COMMENTS

Inspection Record

4 ROOF FRAMING (3RD BELOW)
SCALE: 1/4" = 1'-0"

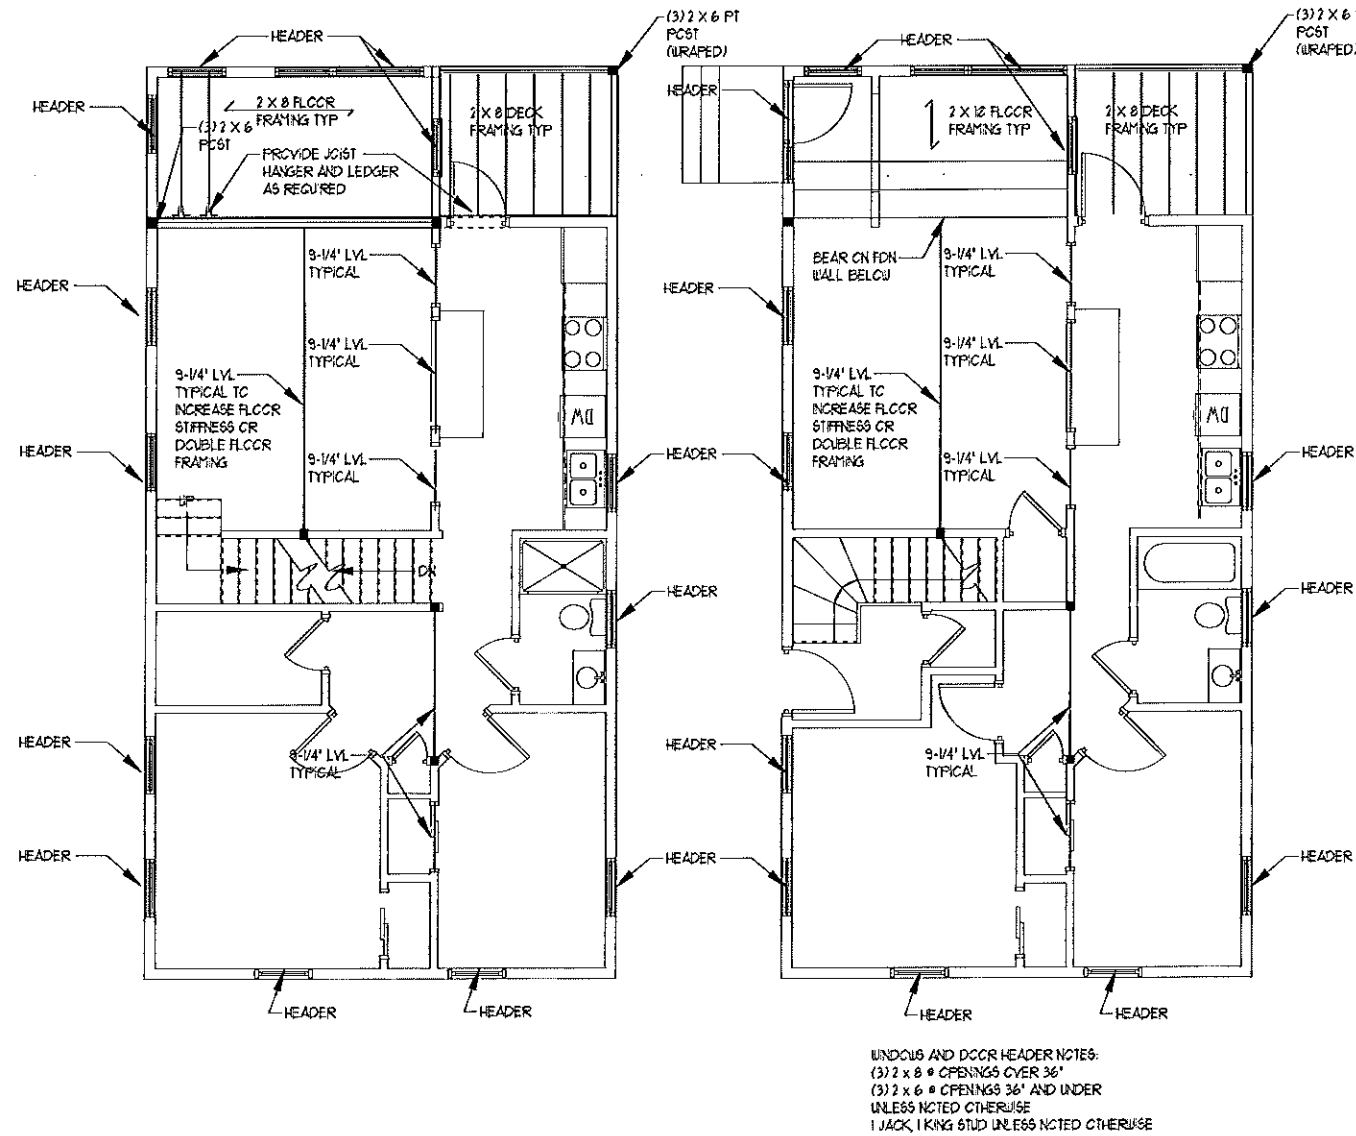
5-2-00 Pre-construction w/owner. Checked Roof framing for structural, will check with Sam if need for additional Joist(rafter) hangers. Yes, Add to each Perpendicular rafter. JB
Checked deck framing All fasteners applied, hangers, connectors to posts and Lagged to house Rim.
Discussed railing height and spacing details. will call for final. JB

5-11-00 Guardrails to 42" all spacing good. Joist Hangers fastened to ceiling rafters per previous inspection JB
